**EIAR Addendum Report in relation to a Large-Scale Residential Development (LRD) Planning Application at Balbriggan, Co. Dublin**

**09<sup>th</sup> March 2026**

The following Environmental Impact Assessment Report (EIAR) Addendum Report has been prepared by Altamar Ltd. on behalf of Glenveagh Homes Ltd. in response to a Request for Additional Information received from Fingal County Council (FCC) on the 20<sup>th</sup> February 2026 (PF/051/26) relating to a proposed Large-Scale Residential Development (LRD) application (Reg. Ref. LRD0069/S3E) at Balbriggan, Co. Dublin. Specifically, this Report focuses on Chapter 4: Biodiversity of the EIAR submitted as part of the planning application (Reg. Ref. LRD0069/S3E).

The purpose of this Addendum Report is to address Items 2(a)[i]-[ix] of the Request for Additional Information (PF/051/26) relating to Chapter 4: Biodiversity of the EIAR.

Figure 4.10: Fossitt Habitats onsite

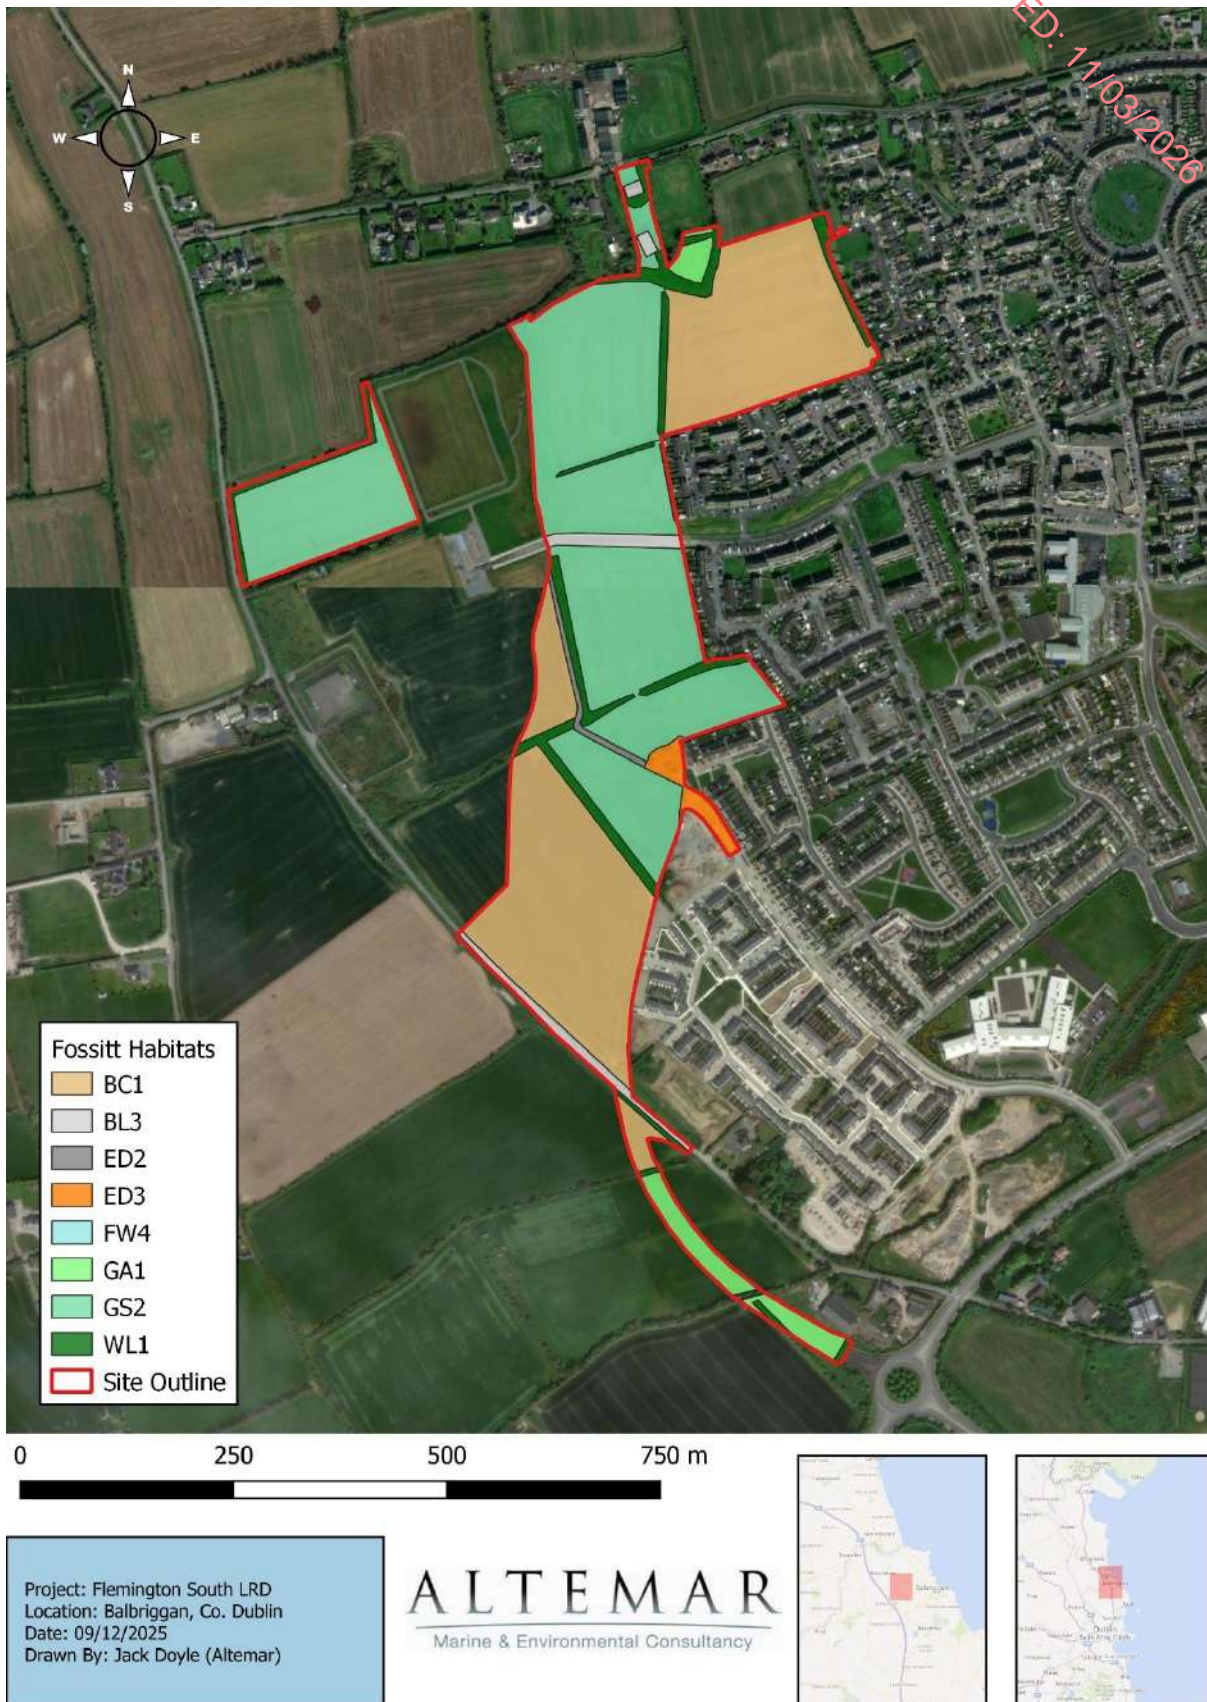
*'Further details regarding the potential usage of the site and surrounding area by reptile and amphibians. Any survey must include all potential surface water features, including the open well to the north of the site, and the drainage ditches/tributary of the Bremore stream which runs along the northern boundary of the site. All drainage ditches and surface water features must be fully accounted for and assessed in the EIAR.'*

*'The most recent site assessment was carried out on the 14<sup>th</sup> August 2025. Habitats within the proposed development site were classified according to Fossitt (2000) (Figure 4.10) and the species noted within each habitat are described.'* (Section 4.3.4 – see Figure 2 for Habitat Map).

*A drainage ditch is located along a hedgerow located to the southeast of the subject site (see Figure 4.10). This drainage ditch appears to serve the adjacent agricultural fields to the north and south. Standing water was observed within this habitat, with lady-fern (*Athyrium filix-femina*) growing along its banks'* (Section 4.3.4)

***'FW4-Drainage ditch***

*As detailed in the Hydrology Chapter (see Section 6.3.1), the site is drained by manmade ditches which may convey flow to the east / southeast towards the Clonard Brook Stream, Clogheder Stream and Bremore Stream during periods of heavy rainfall. Further, the Hydrology Chapter indicates that these ditches only serve the subject site and agricultural fields immediately west and do not convey any upstream watercourse.*

*During the site inspections carried out by Altemar, a number of drainage ditches were observed along field boundaries and the base of linear hedgerows. However, no standing or flowing water was observed in any of these habitats. No reptiles / amphibians, or features suitable for reptiles / amphibians, were recorded along these habitats.*

*The only drainage ditch to display standing water during Altemar's site inspections is located to the southeast of the subject site (see Figure 4.10). This drainage ditch appears to serve the adjacent agricultural fields to the north and south. Standing water was observed within this habitat, with lady-fern (*Athyrium filix-femina*) growing along its banks. No reptiles / amphibians were recorded within this surface water feature, however, this habitat is suitable for these species.'*

*The historic Spring is known as 'Lady Well' was noted within a hedgerow habitat to the north of the subject site. This feature did not display a surface expression of a well structure (although one could be concealed by overgrowth of vegetation) and did not display any significant surface water discharge to the surrounding environment. No reptiles / amphibians were recorded within this feature.'*

Figure 2. Tree removals plan (north)

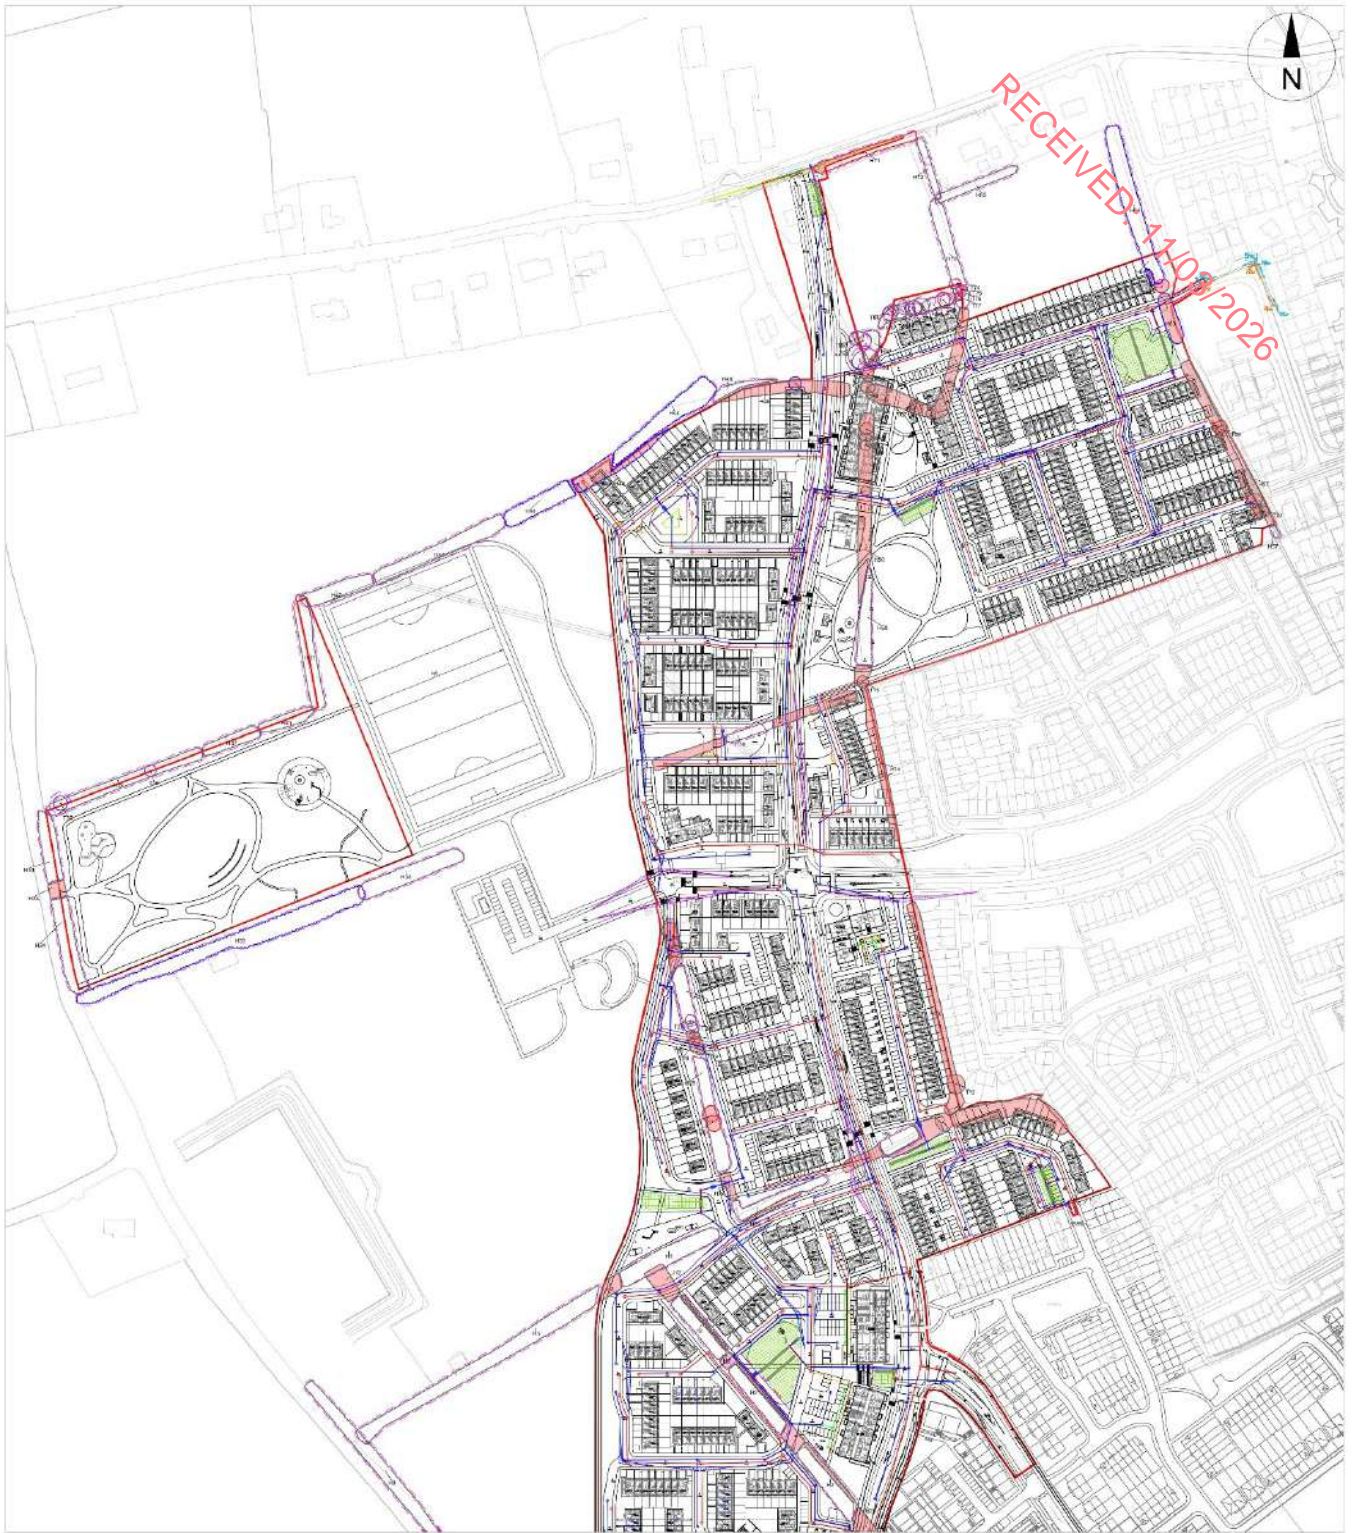
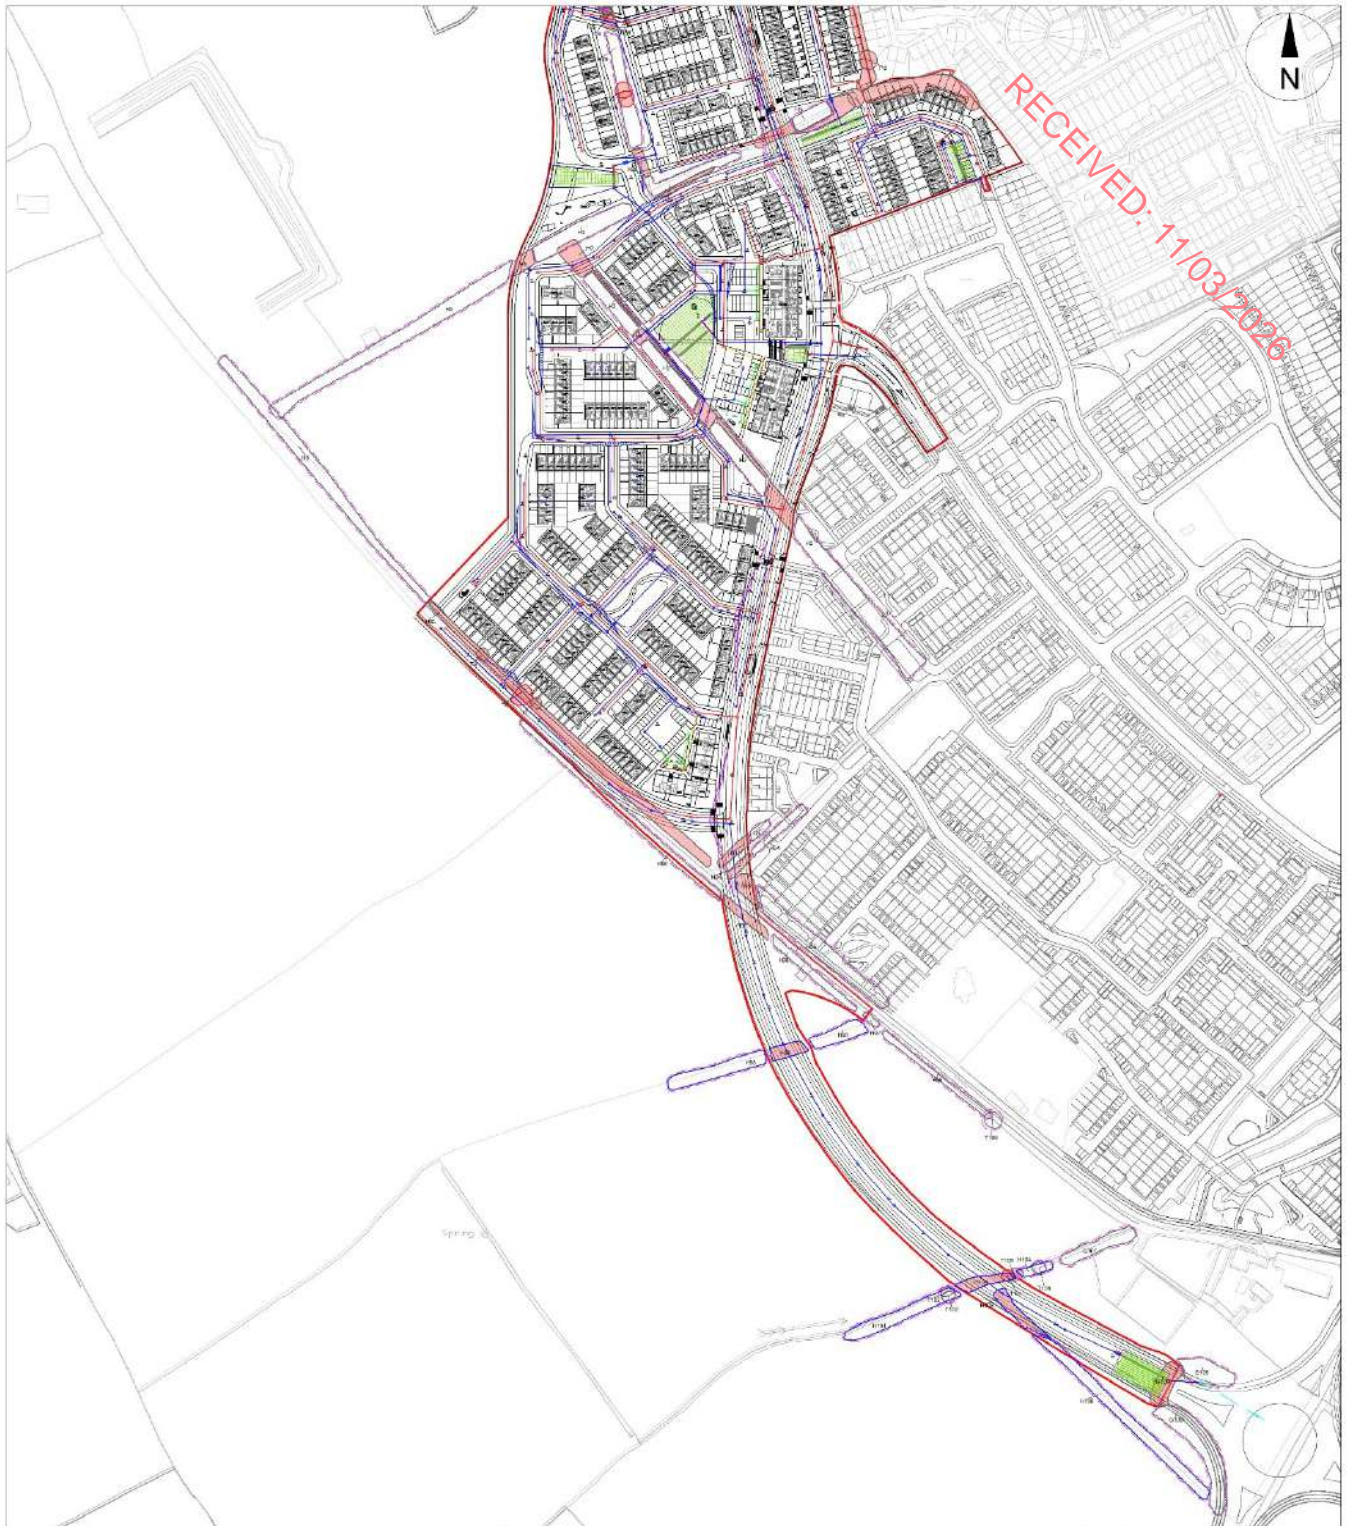
- vii. Tree removal plans from EIAR Appendix I Arboricultural Report are missing. This is required to be provided in order for a robust assessment to be made on the hedgerows and trees that will be lost to the proposed development.*
